From: Judith Ward
Sent: 09 April 2020 07:38
To: Linda Griffiths
Subject: 19/00895/REM OS parcels 6741 and 5426 LAP/LEAP/MUGA

MUGA

LAP/LEAP

Drawing file: 2832-5-2-DR-5014 P3 LANDSCAPE PROPOSALS.pdf

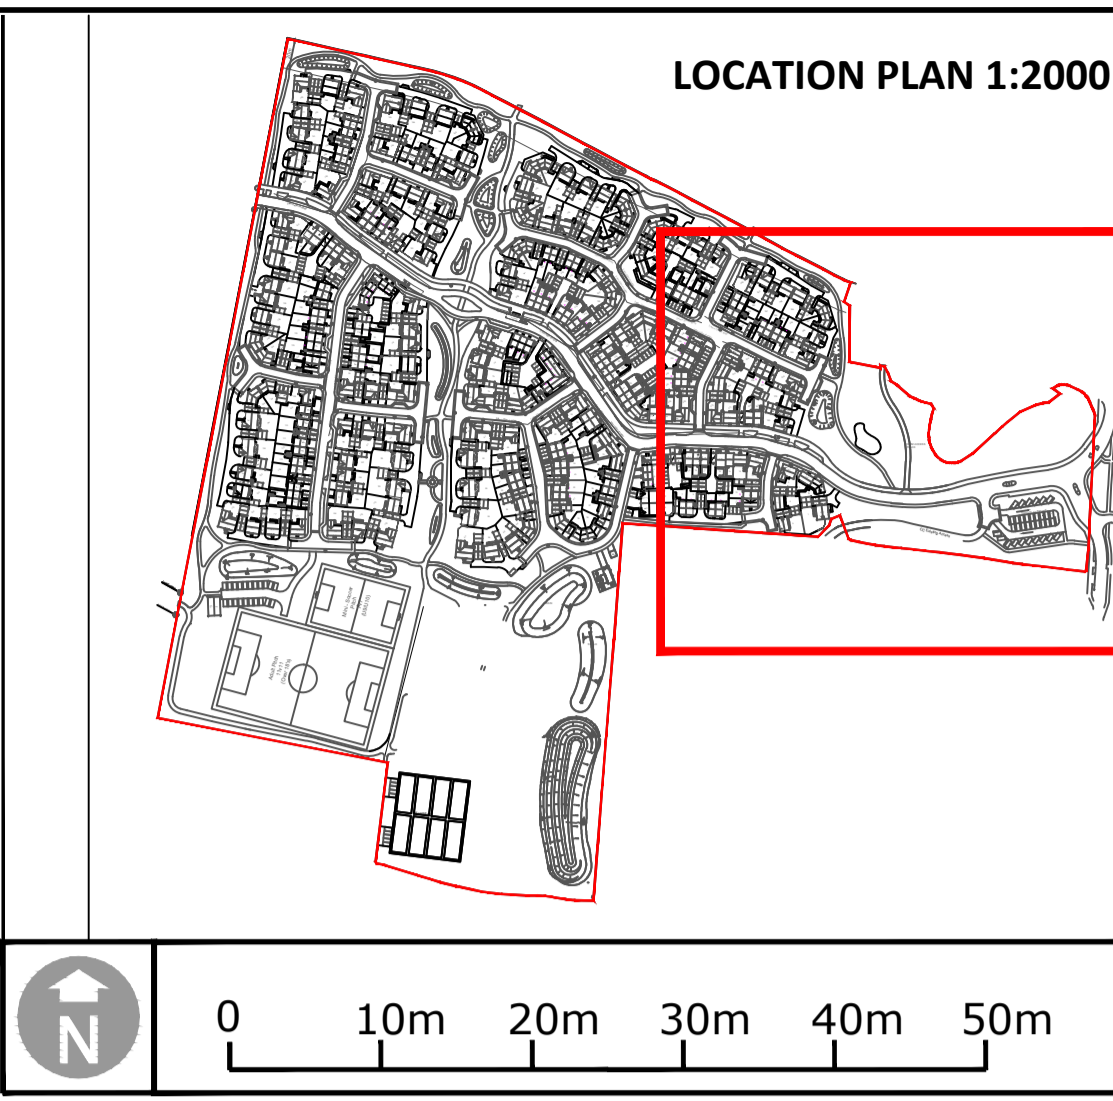
Very few seats shown.

Why is there a mown path leading to the southern boundary hedge when it can't go further?

The plant species are difficult to read at 1:500 at A1

Hedge mixes should avoid climbers as they throttle the shrubs in the establishment phase.
